West Burton Solar Project

Statement of Common Ground with Historic England Revision A

PINS reference: EN010132
Document reference: EX5/WB8.3.3_A

Figure 1. Location of heritage assets associated with Stow Park Deer Park, Stow Deserted Medieval Village and a possible early medieval settlement in the west of West Burton 3.

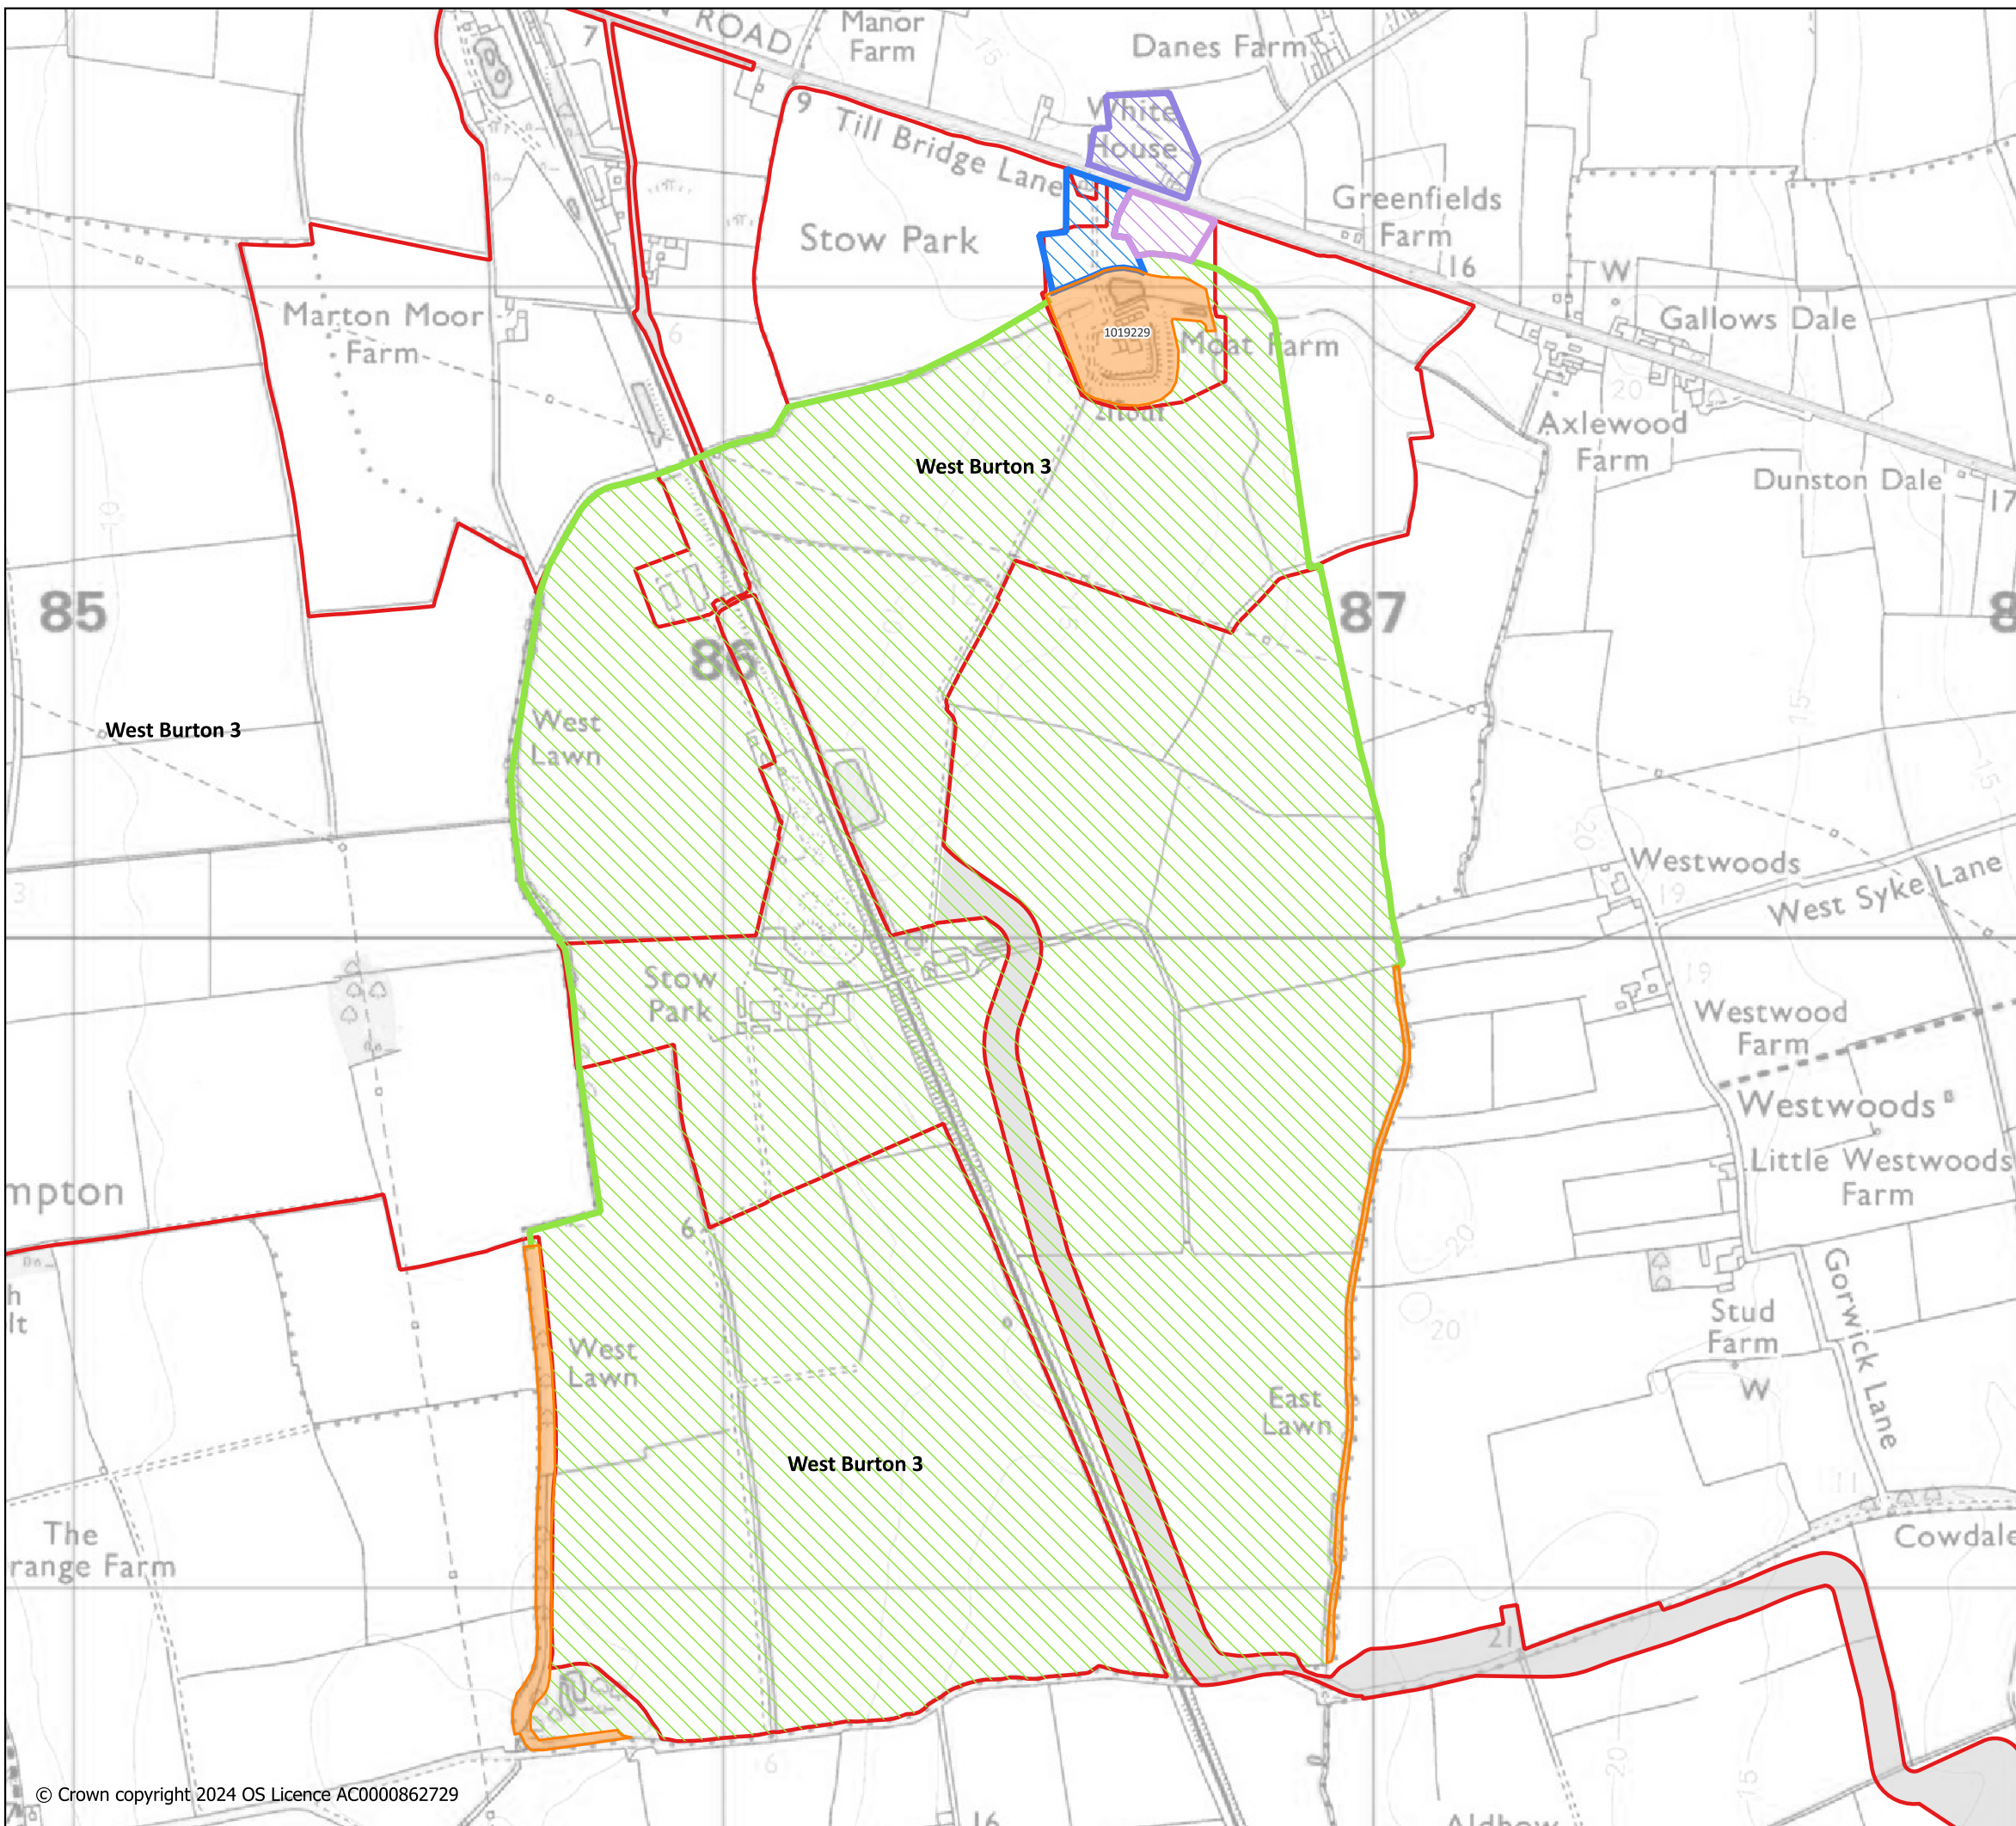
Item	Applicant Position	Historic England Position
Level of harm	<p>The Applicant believes that Scheme would cause less than substantial harm (at the upper end) to the significance of Medieval Bishop’s Palace and Deer Park, Stow Park Scheduled Monument (NHLE 1019229), which is derived from changes to its setting through the introduction of solar panels.</p> <p>The introduction of solar panels would not cause direct harm to the fabric of the three isolated elements that constitute the Scheduled Monument and that form the only surviving vestiges of the Deer Park. Due to the distances between these elements of Scheduled Monument and the lack of coherent sightlines, the legibility of the landscape would be unaltered and the reversible nature of the Scheme means that any harm to the setting of the Scheduled Monument</p>	<p>HE considers that the impact of the Scheme on land within the former Deer Park as defined by Medieval bishop’s palace and Deer Park, Stow Park Scheduled Monument (NHLE 1019229) would cause substantial harm (in NPS/NPPF terms) / significant environmental impact (major harmful; in EIA terms) to the significance of the Scheduled Monument through loss of its character as a bounded architectural space. Consequently HE <i>“object to installation of any part of the development within the former Deer Park (as defined by the lines of the scheduled Park Pale and its former course).”</i></p> <p>For extent of the Deer Park see the appended agreed map.</p>

<p>would be removed following decommissioning of the Scheme.</p>	
<p>Composition</p>	<p>The Medieval bishop's palace and Deer Park, Stow Park Scheduled Monument (1019229) is composed of three physically separate elements. These are the site of a moated Bishop's Palace, the west section of park pale and the east section of park pale.</p> <p>The internal section of the Deer Park does not have any designation (i.e. form a Scheduled Monument, Registered Park and Garden, or Conservation area). The Applicant believes that this is largely due to the absence of any landscape features that are associated with the Deer Park and that would add to our understanding of how the Deer Park functioned. The Applicant believes that while it is possible to postulate from more well preserved examples of deer parks—which contain landscape features that demonstrate how the Deer Park would have formally functioned (i.e. Ravensdale Deer Park in Derbyshire which is designated as a Scheduled Monument and Conservation Area)—where features typically associated with a deer park may have been located at Stow Park, there is a paucity of evidence base to confirm any correlation.</p> <p>The Applicant believes that the various Scheduled areas can only be experienced individually and in relatively close proximity. Therefore, the Applicant believes that the 'architectural' space of the Deer Park is derived from the historical spatial relationship between the three sections of</p>	<p>Historic England stated in their relevant representation that <i>"the impact of the proposed installation within the former Deer Park represents substantial harm (in NPS/SPPF terms) to the significance of the monument through loss of its character as a bounded architectural space."</i> Historic England believes that <i>"this represents a significant environmental impact (major harmful) in EIA terms."</i></p> <p>As detailed in their Relevant Representations <i>"The Medieval Bishop's Palace site and Deer Park is set on the Roman road from Lincoln to Doncaster a key line of communication between the Episcopal sees of Lincoln and York. Deer parks and palace / lodges offered a place for retreat, rest and entertainment of social and political peers, clients and Royal guests and were hence key spaces for the performance of the elite status of Bishops in the medieval landscape. The Deer Park is an architectural space, a place cut out from the overlapping and complex medieval landscape, a place where rights were monopolised - in this instance [by] the Bishop. At the heart of the significance of a medieval deer park is not just the functional containment and protection of deer and other resources but also their articulation as a space apart - a space imparked. This central aspect of significance would be profoundly compromised by the loss both of its rural character through the installation of panels and by it being subsumed into a new landscape of solar generation.</i></p>

<p>the Scheduled Monument bounding the area, which is largely defined by cartographic evidence.</p>	
<p>Legibility</p>	<p>The Applicant believes that the overall legibility of the Deer Park is largely understood through desk-based research, particularly aerial imagery and historical documentation. Land within the Deer Park has been adversely compromised by the removal of associated features after disemparkment and subsequent post-medieval and modern activity, resulting in a lack of coherent legibility when experiencing the Deer Park at ground level. Given the Scheme would not cause direct harm to the three elements of the Scheduled Monument, which form the remaining vestiges of landscape features associated with the Deer Park, the Applicant believes that any current legibility of the Deer Park would not be negatively altered by the presence of solar panels.</p> <p>As stated in Paragraph 3.3.34 of the Heritage Statement (6.3.13.5 Environmental Statement - Appendix 13.5 Heritage Statement [APP-117 to APP-119]), the Applicant acknowledges that the Scheme has the potential to physically and visually isolate the three elements that make up the medieval bishop's palace and Deer Park Scheduled Monument. However, as identified in Paragraph 3.3.35 of the Heritage Statement [APP-117 to APP-119], the Applicant believes that the relationship between the three surviving components of the Deer Park has already been adversely compromised: modern activity including the ex-MOD petroleum storage facility and a railway line completely bisect the Deer Park, resulting in there being no intervisibility between the west park pale, and the Bishop's Palace and east</p>	<p>Historic England stated in their relevant representation that <i>"The railway and associate ex MOD petroleum storage facility represented significant change to the former Deer Park by bisecting the site, but they have not fundamentally compromised the ability to experience the park as a space defined in the landscape. As one walks from the moated site at the north to the raised ground occupied by the farm buildings at the south of the park and then crosses the railway past the fuel depot to the farmstead and the south western part of the park one can still gain a sense of this as a bounded space."</i></p> <p>HE stated in ISH5 that the significance of the medieval bishop's palace and deer park, Stow Park as a bounded architectural space can still be experienced as a whole despite the dissection by the railway, one can appreciate and understand the park kinetically from the Palace moving through the park southwards over the railway via the modern bridge.</p>
